WEST SUSSEX COUNTY COUNCIL CONSULTATION

TO:	Arun District Council FAO: Mr S Davis
FROM:	WSCC - Highways Authority
DATE:	22 November 2019
LOCATION:	Rear of Inglenook Hotel 253-255 Pagham Road Bognor Regis PO21 3QB
SUBJECT:	P/58/19 Erection of 9 No. dwellings with associated access, parking, cycle & refuse storage & landscape design. This application is a Departure from the Development Plan & may affect the setting of a listed building. Additional information received.
DATE OF SITE VISIT:	20/11/2019
RECOMMENDATION:	More Information
S106 CONTRIBUTION TOTAL:

Scale	1:500	Drawn By	SMO	Checked By	ALB	Approved By	PMR
Date	May 2018	Drawing No.	2017-3763-001	Rev.	A

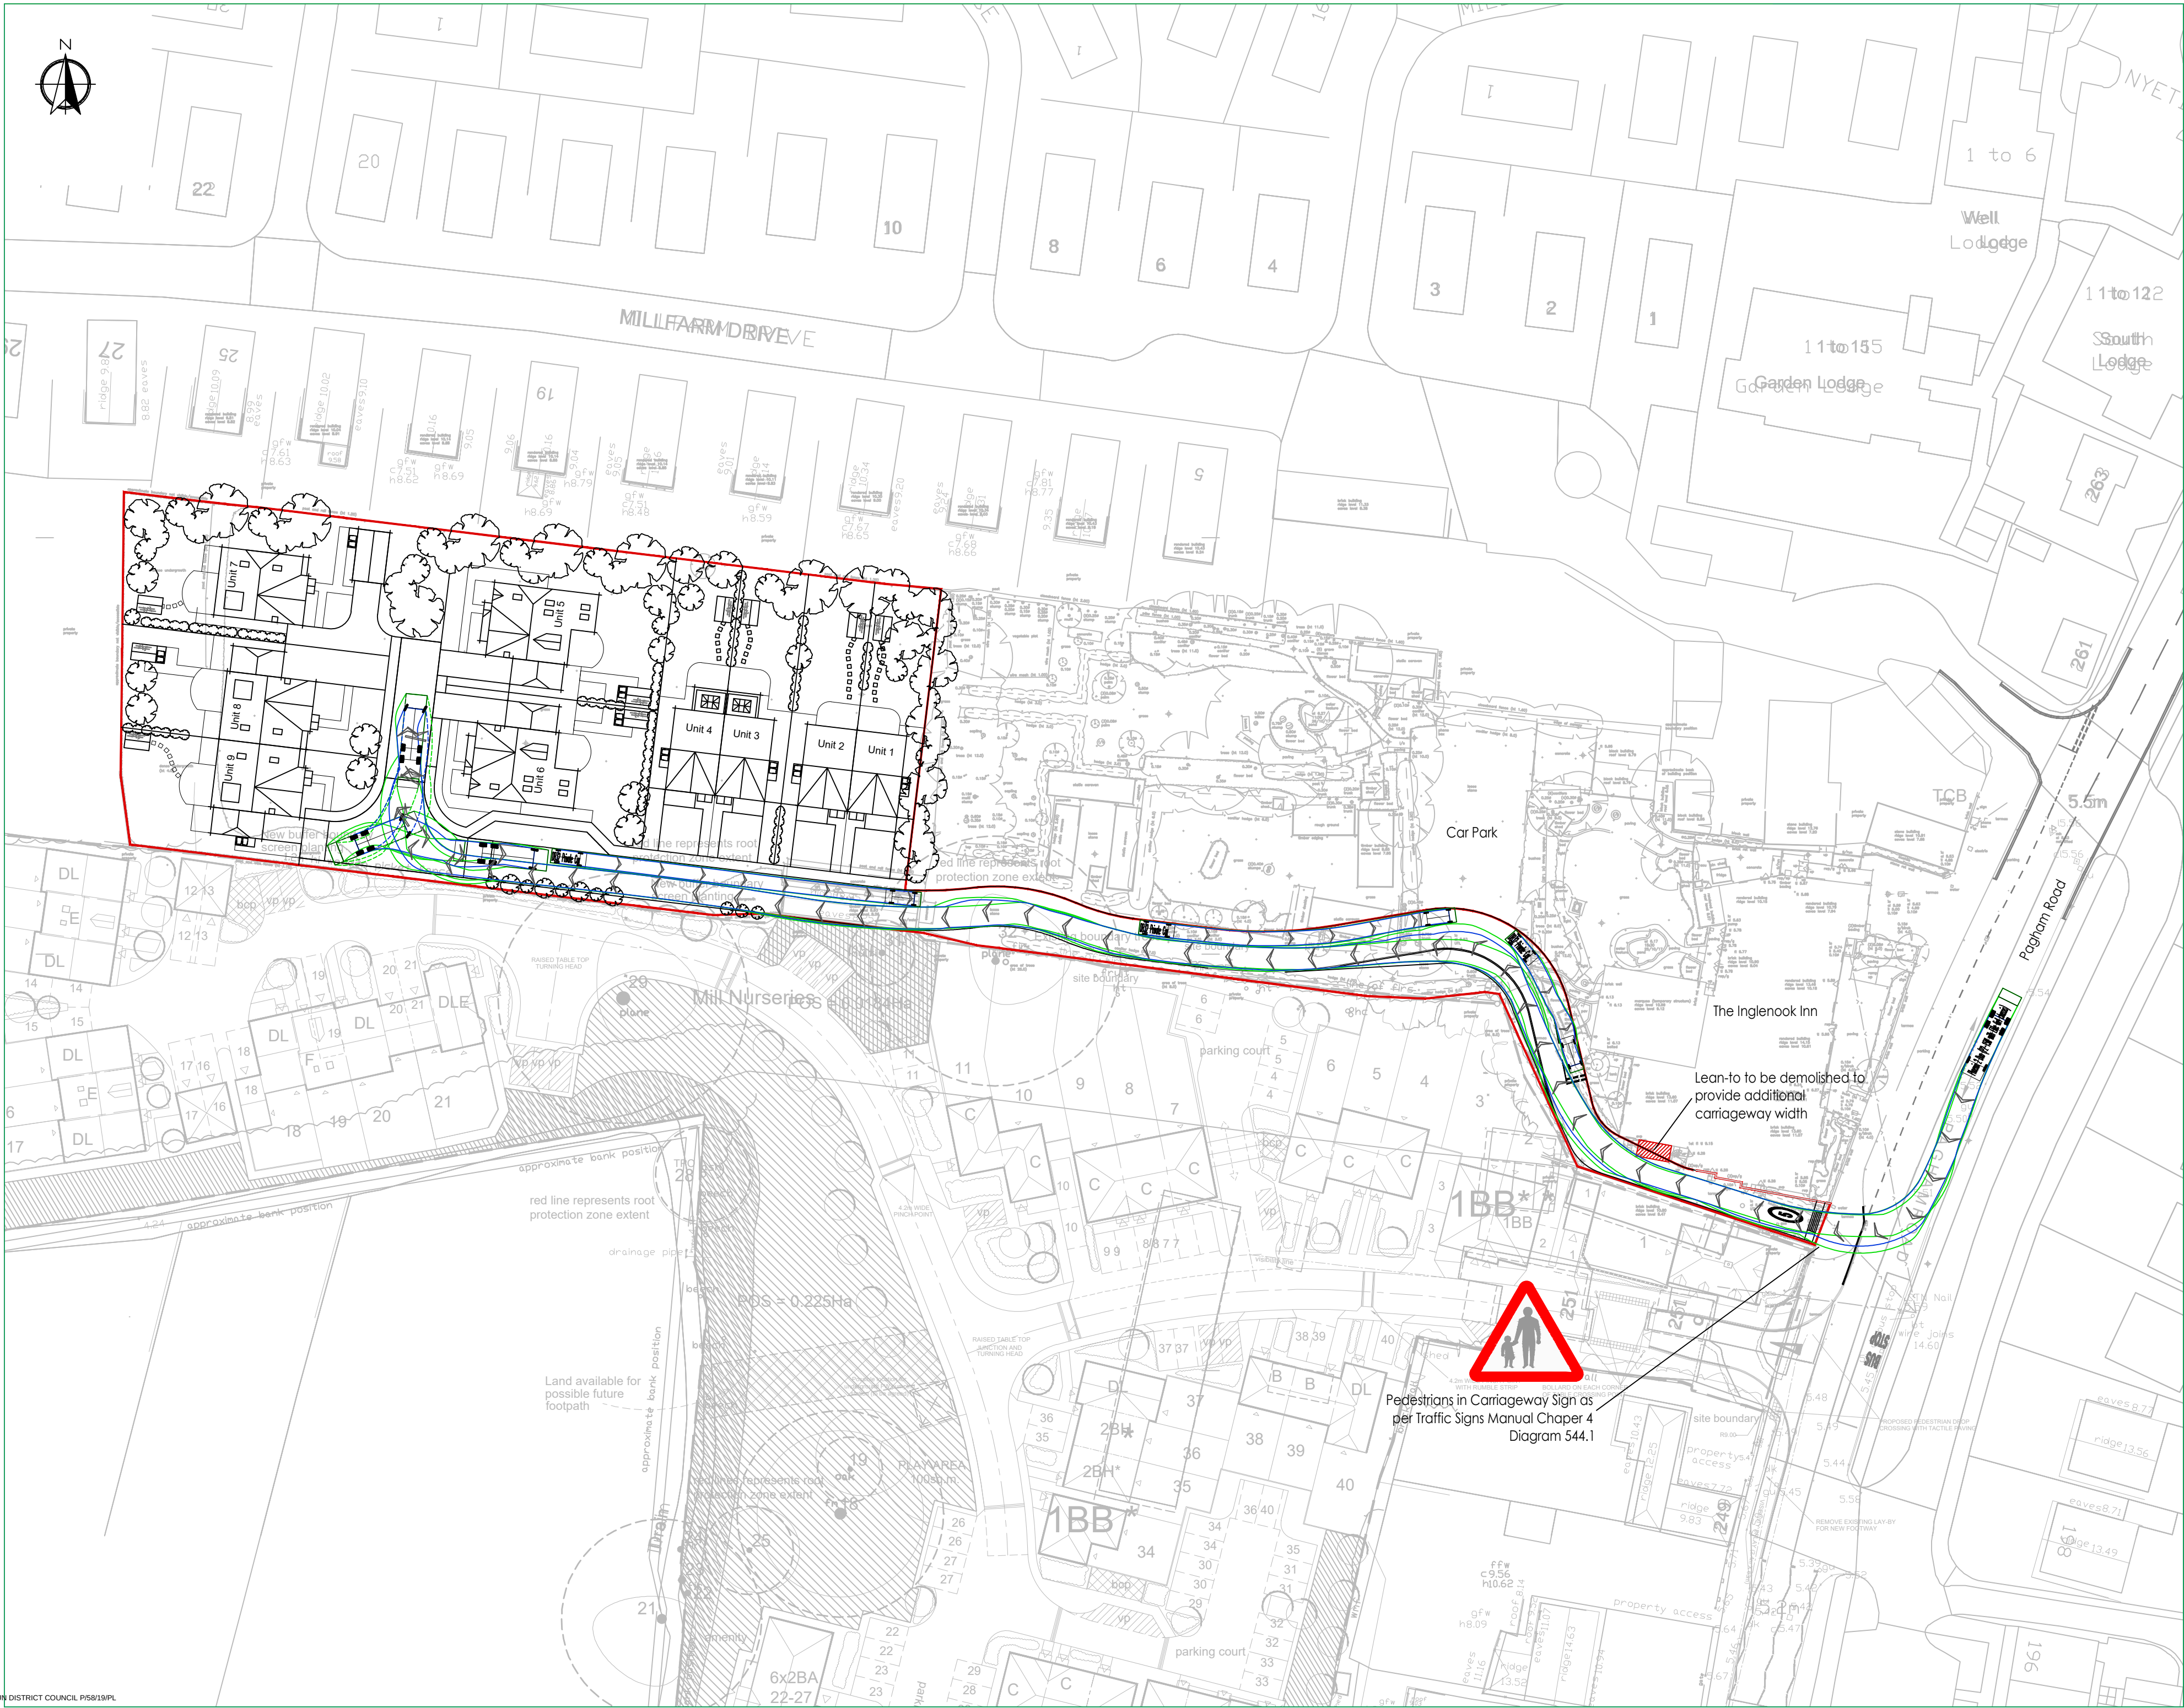
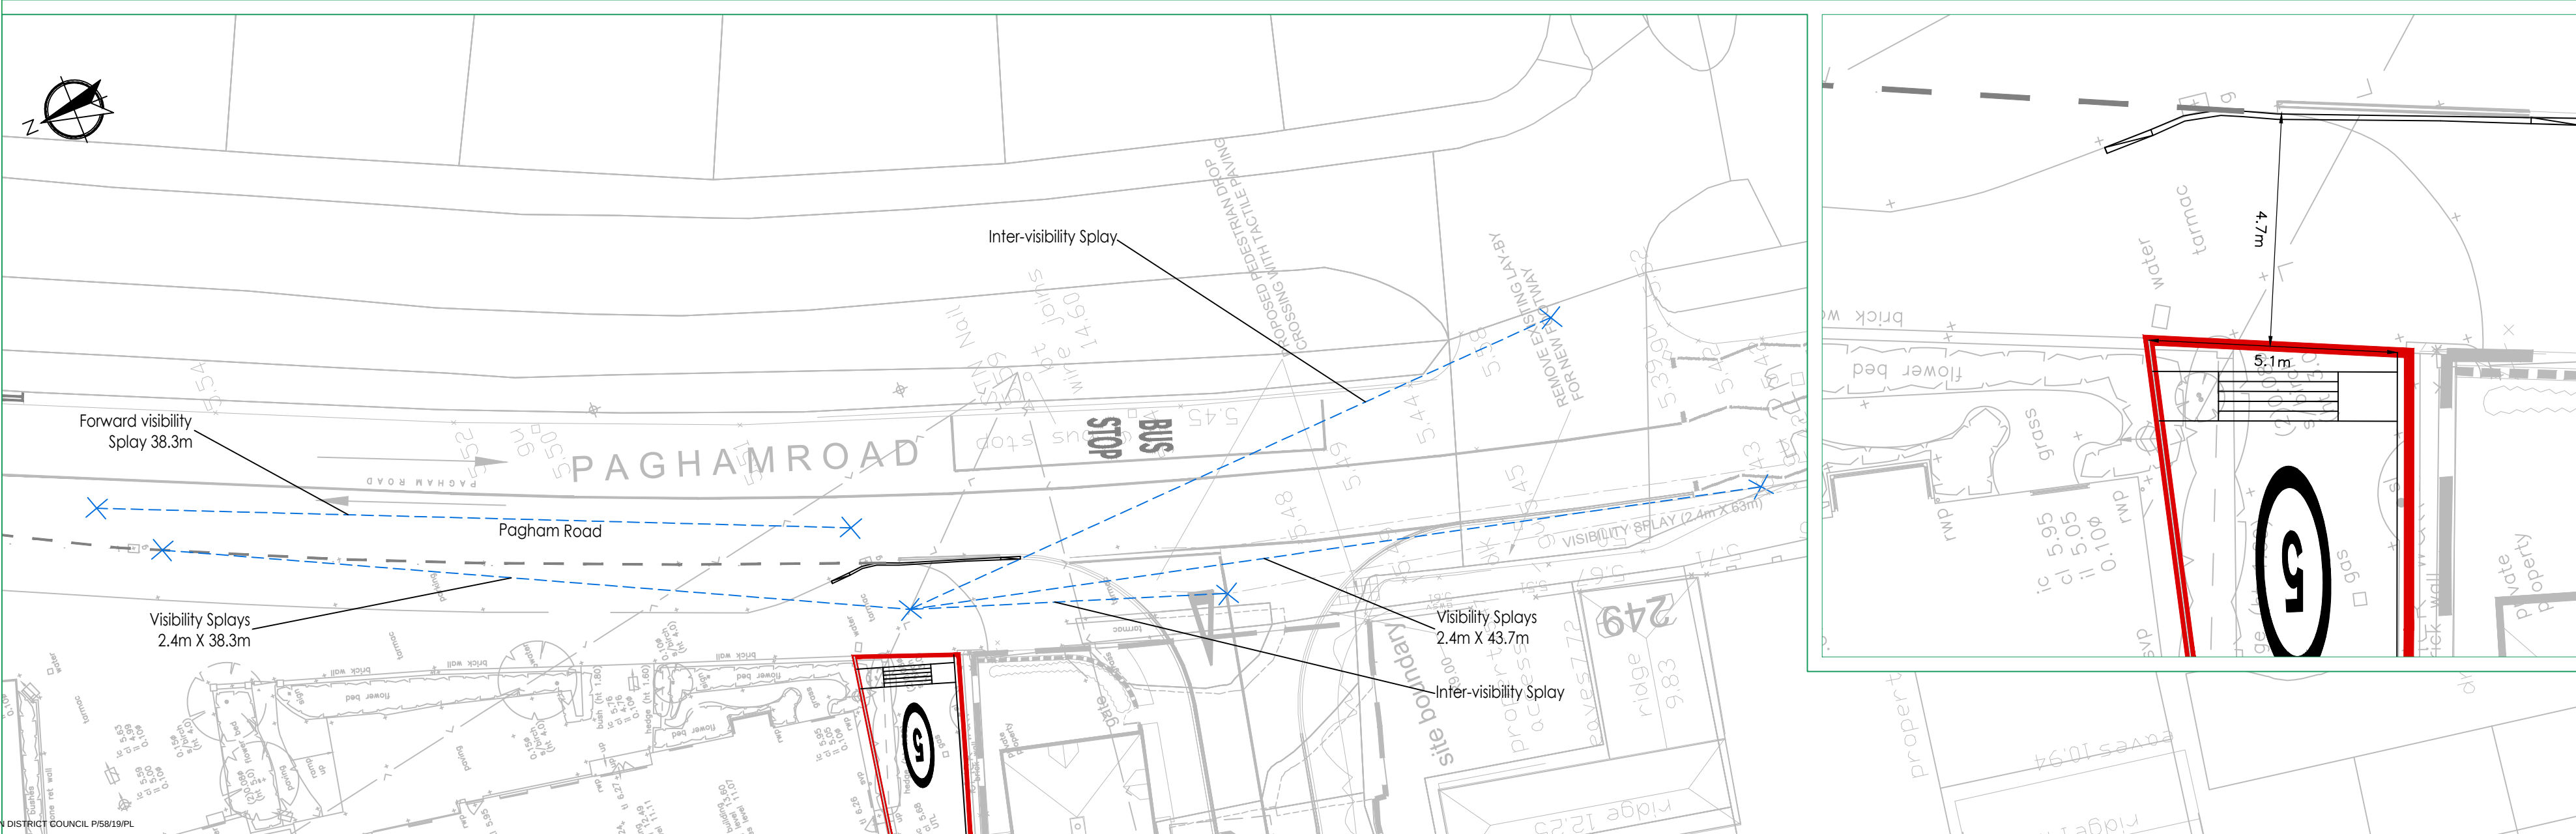
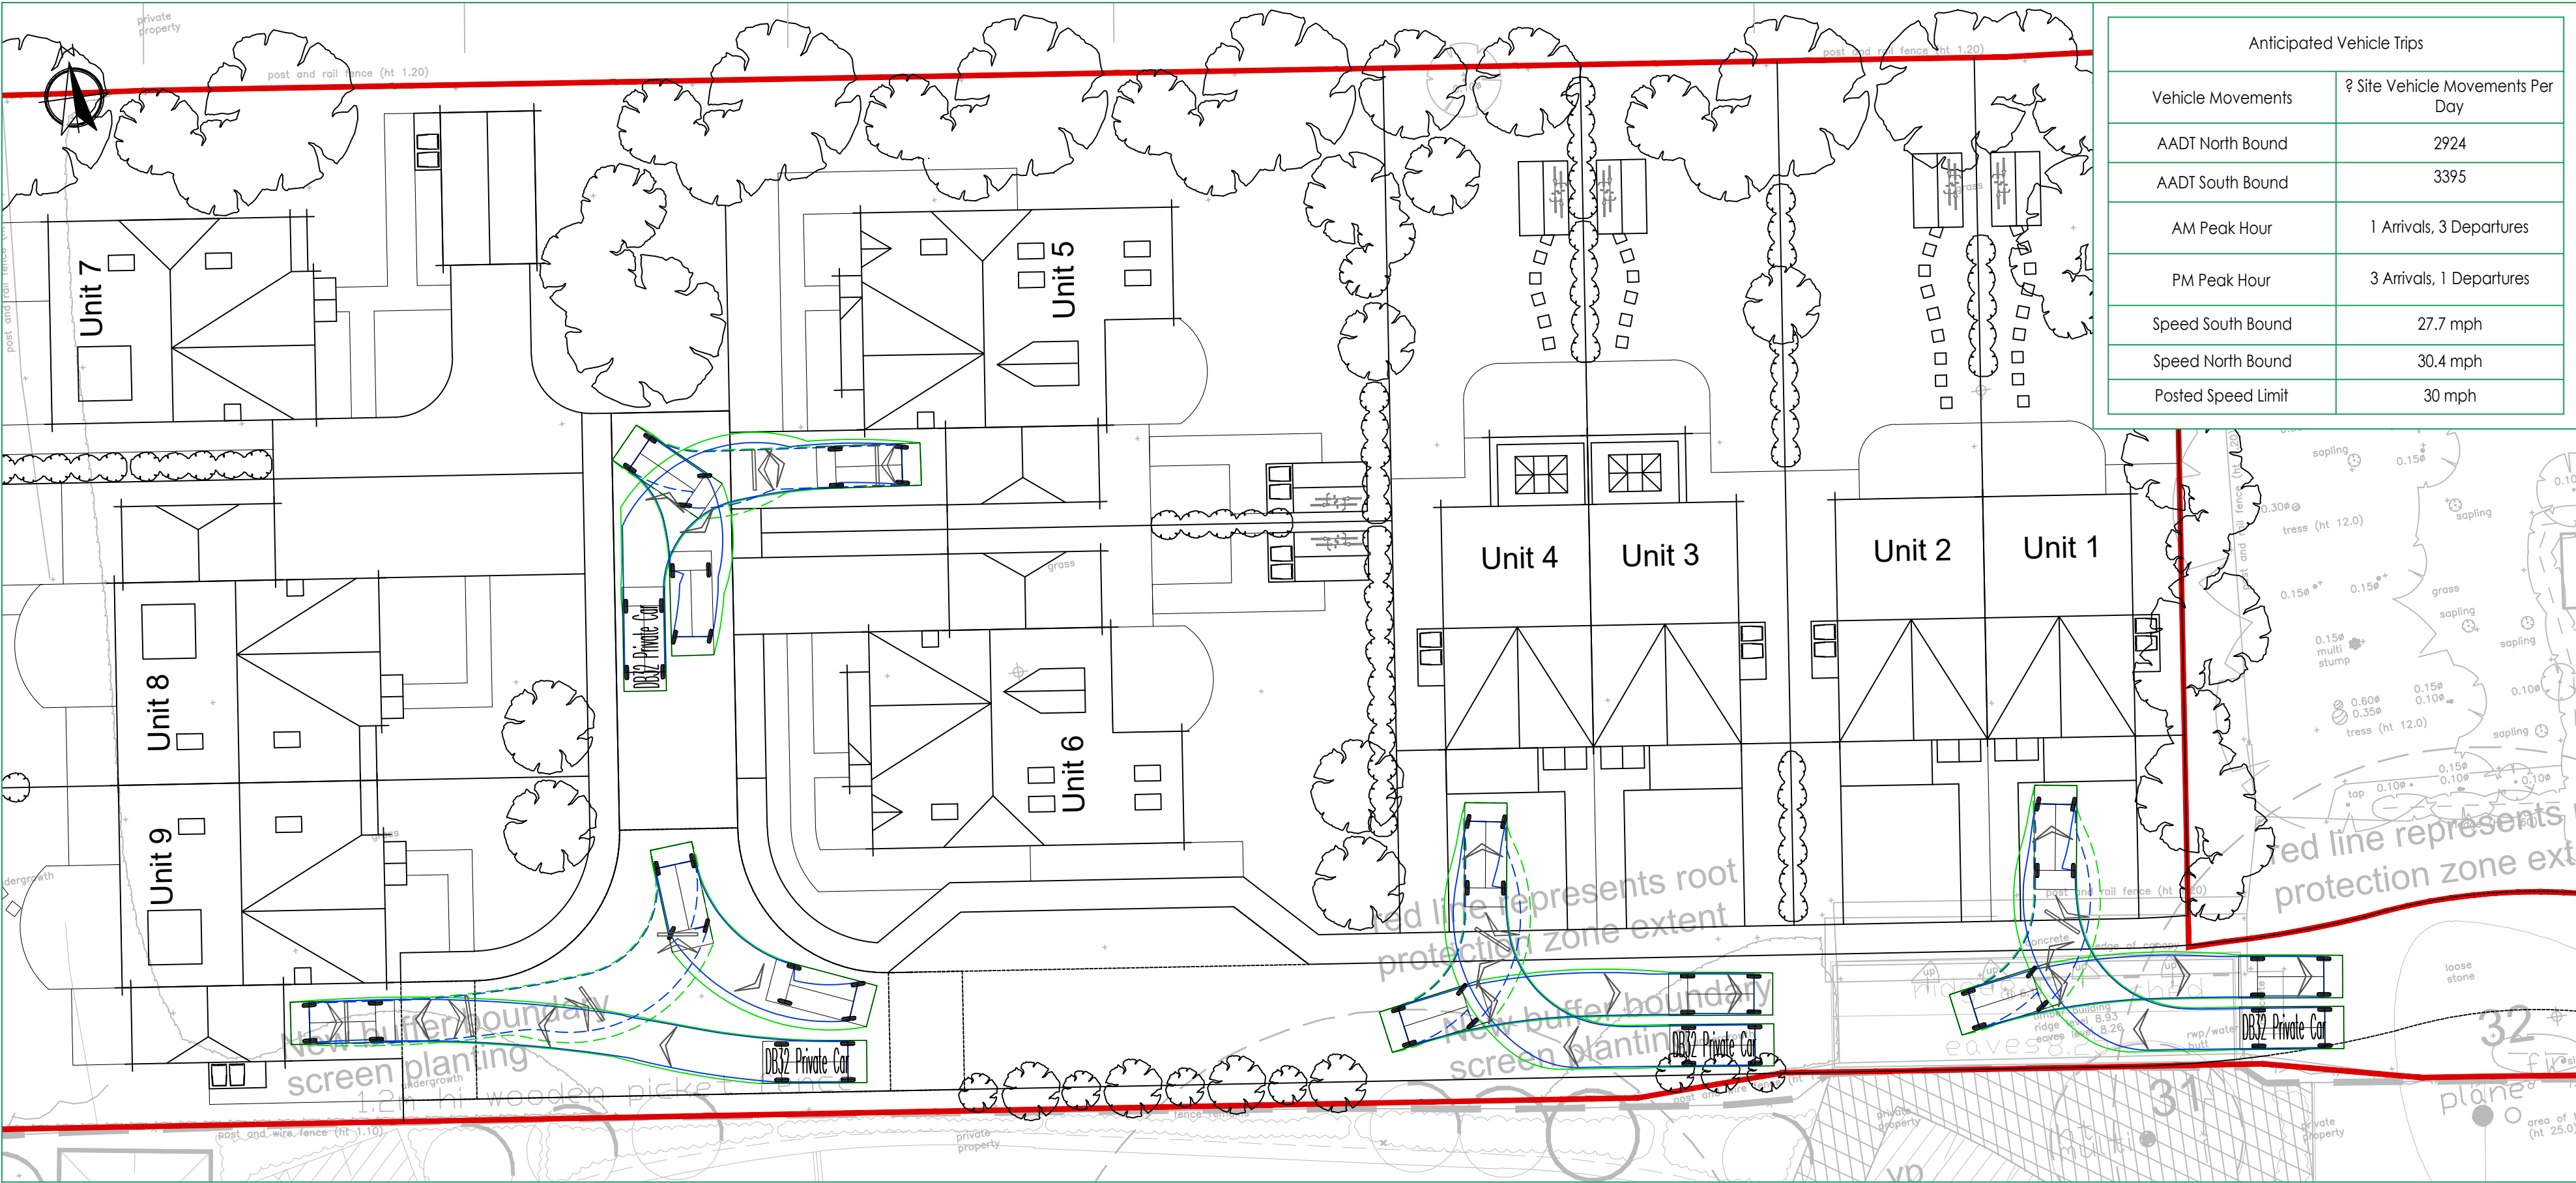
Due to the nature of the access as shared with the existing pub/hotel use there were concerns raised that patrons of the Inglenook may not be aware of the shared surface use that will be implemented as a result of this proposal. Although the access does appear to be currently used by residents of the hotel to access their accommodation after hours, it is appreciated that those unfamiliar with the location may not be aware. The LHA request that the applicant provide details of an internal sign advising vehicles entering the site that pedestrians will be sharing the route.

There is a left hand turn along the access route as the road meets the existing car park. Currently on the inside of this bend, along the eastern boundary with the neighbouring Crayfern site there is a line of trees which may restrict the visibility splay for emerging vehicles and pedestrians. The LHA note that the existing forward visibility splays intersect this tree and vegetation and that there is scope for improvement. It is not clear whether this will be present in the final design however; the applicant should demonstrate removal of this tree or cutting back of vegetation at this point to assist with visibility for all users. The forward visibility should then be redrawn to reflect these changes

The access route is currently surfaced up to the existing car park where it then turns to pea shingle and in parts appears to remain unmade. Given that an accessible unit is provided the applicant should consider how wheelchair users would navigate this route given that the wheels of the wheelchair do not operate well on pea shingle and that uneven unmade routing is not considered sufficient to accommodate wheelchairs, parents with pushchairs and users with sight impairments.

Appropriate surfacing should be demonstrated throughout the access route to mitigate this. The developer must then show the routing proposed from the accessible unit, all the way through the site to the footway showing how these users would make their way through the site. This should also take into account the internal footways proposed and show relevant widths and dropped crossing points for these pedestrian routes.

It may be appropriate to provide delineation between surfacing for vehicles and surfaces for pedestrians to denote an area where pedestrians are encouraged to travel. This would provide more vulnerable users with a clear route to use and deter vehicles from the potential of encroaching on the space.
